19th April 2021

Re: Proposed Non-Material Amendment (pursuant to Section 96A of the Town and Country Planning Act 1990) to Planning Permission CM/16/18/PL

This application seeks to make the following amendments to the planning permission through a change to the approved plans and drawings listed within condition 2 as well as an amendment to the wording of condition 6:

drawing title:
M9316- HUN- 02- SL- DR- A- 13-0020

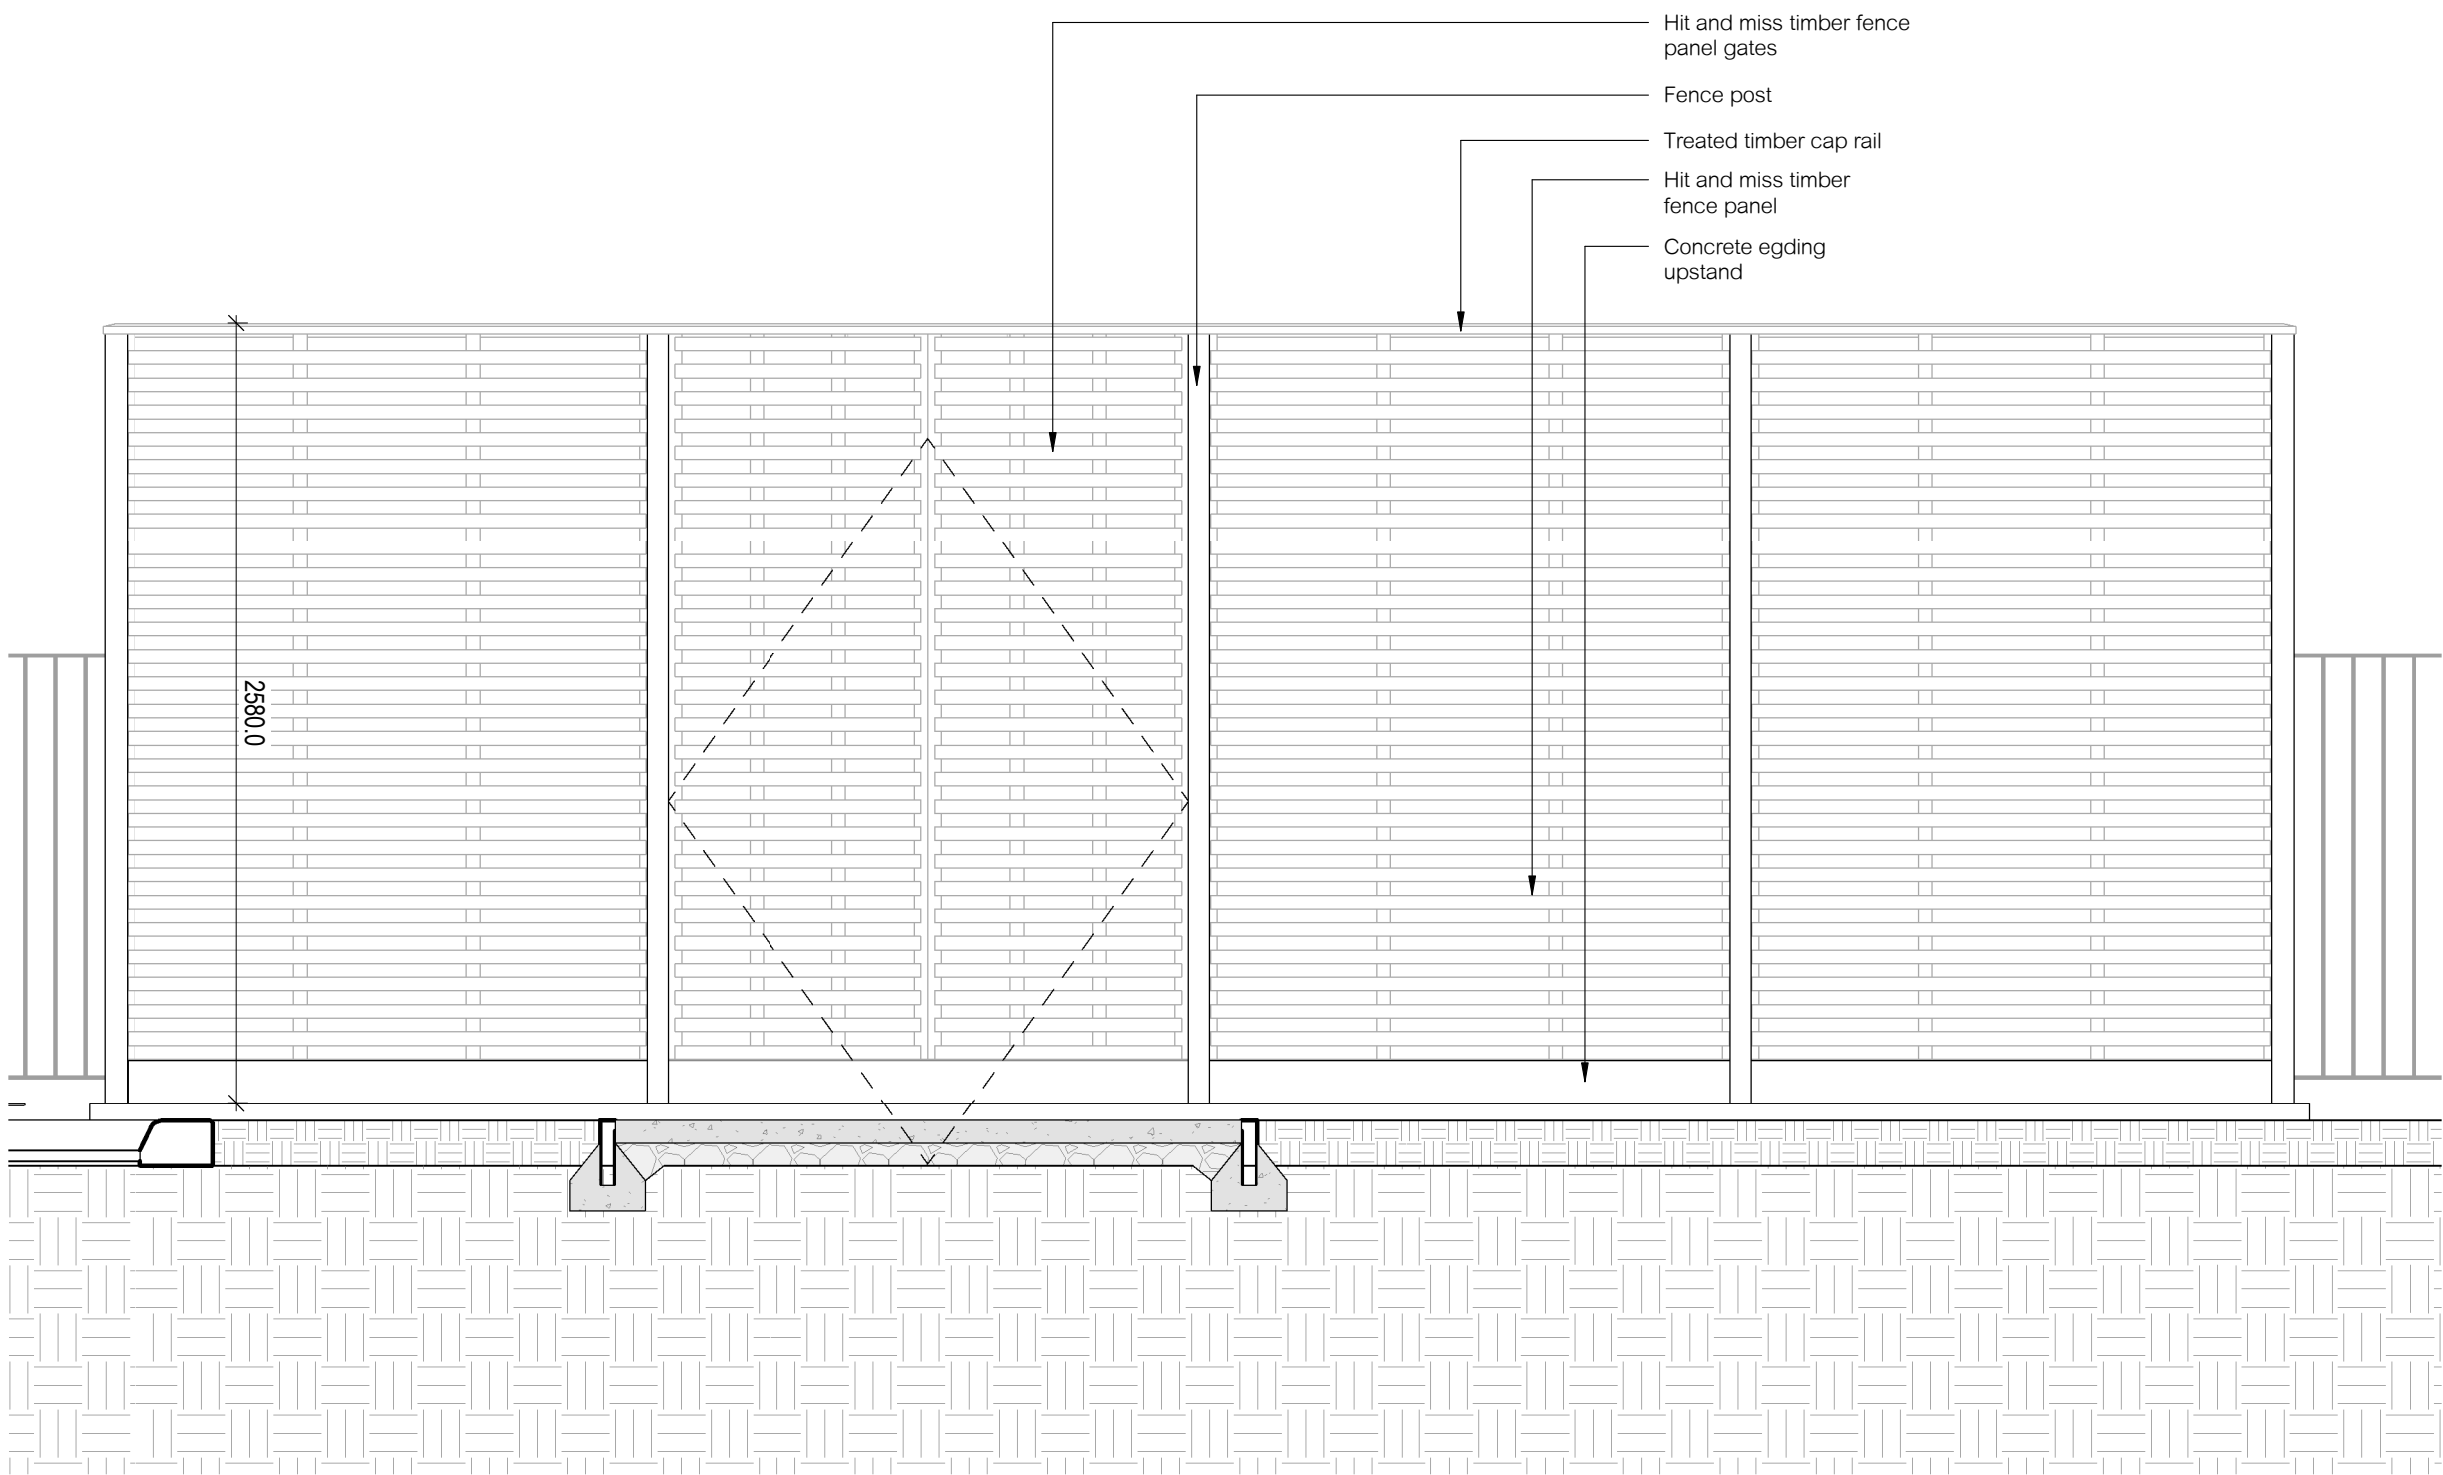
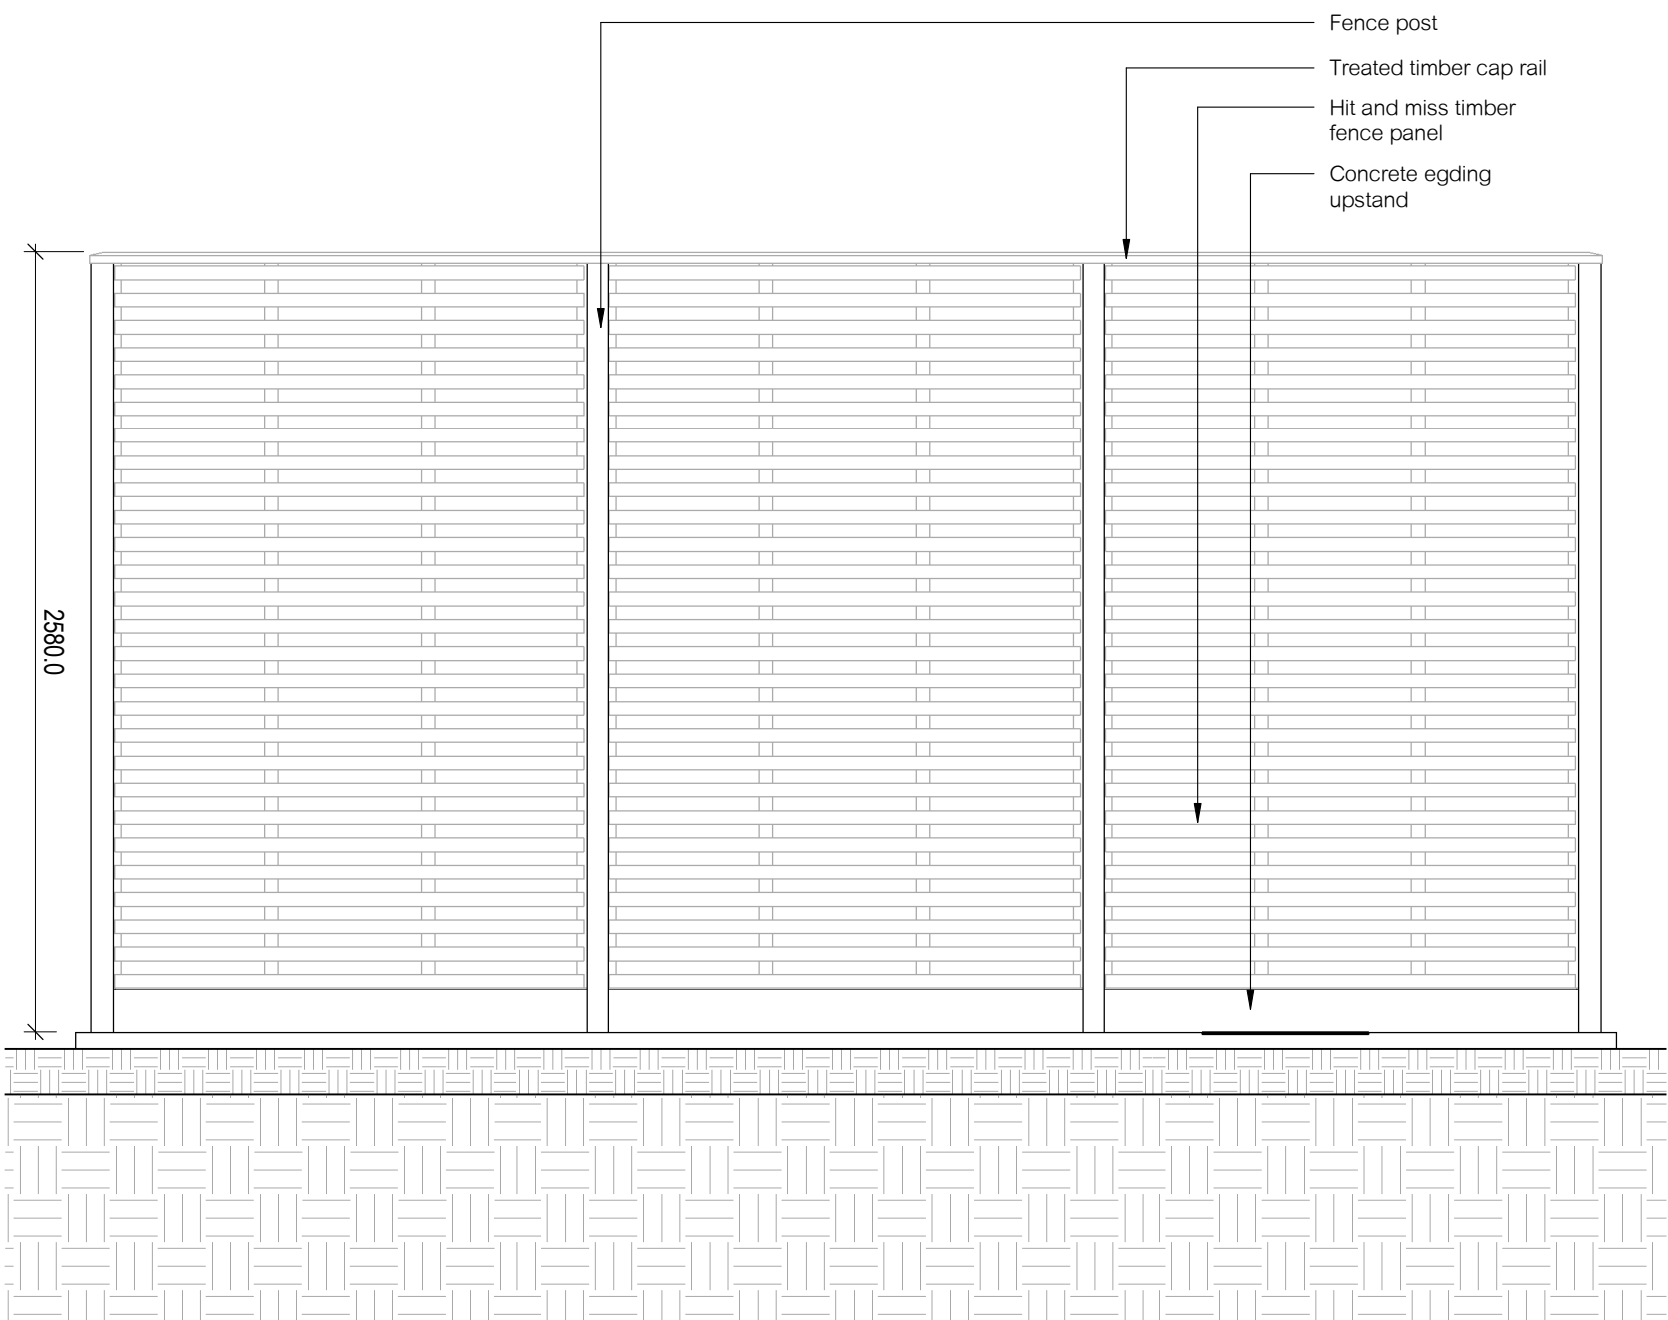
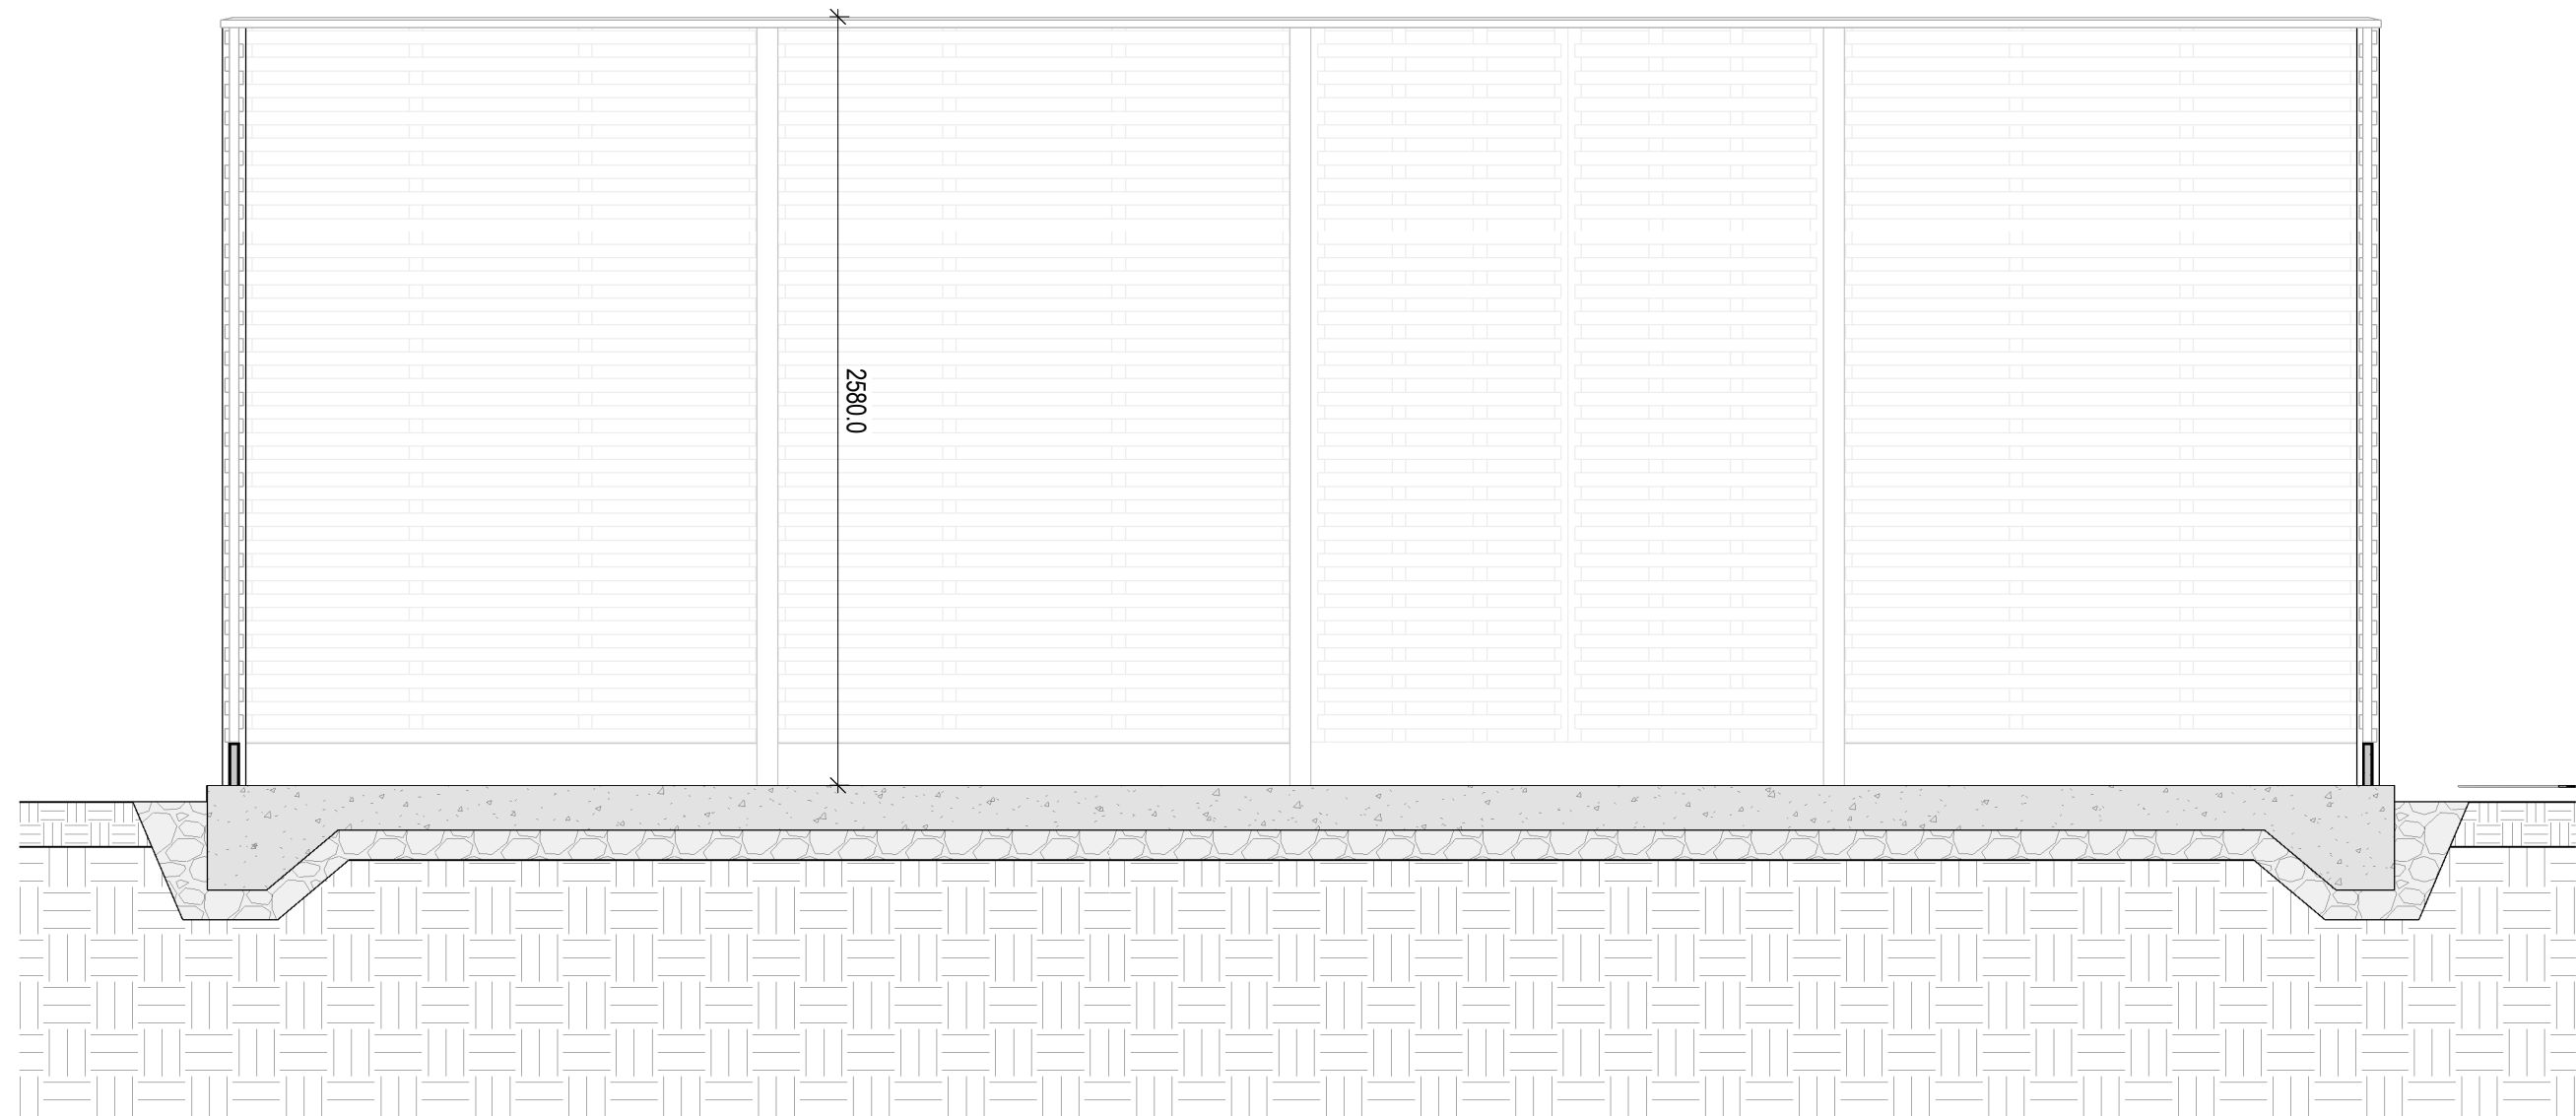
3. The introduction of air source heat pumps (within an associated enclosure) together with a new electricity substation on the site. In developing the detailed construction specification for the new care home for the operator, an objective throughout has been to reduce the development's carbon footprint. An 'all electric' design with roof mounted photo-voltaic panels is therefore proposed which would reduce the CO2 generated by the development by 40% and obviate the need for connection to the gas network. In order to achieve the 'all electric' design, generate hot water and maximise the benefit of the free electricity provided by the photo-voltaic panels, air source heat pumps are required on the site and which are proposed to be located in a secure external plant enclosure constructed of timber hit and miss fencing.
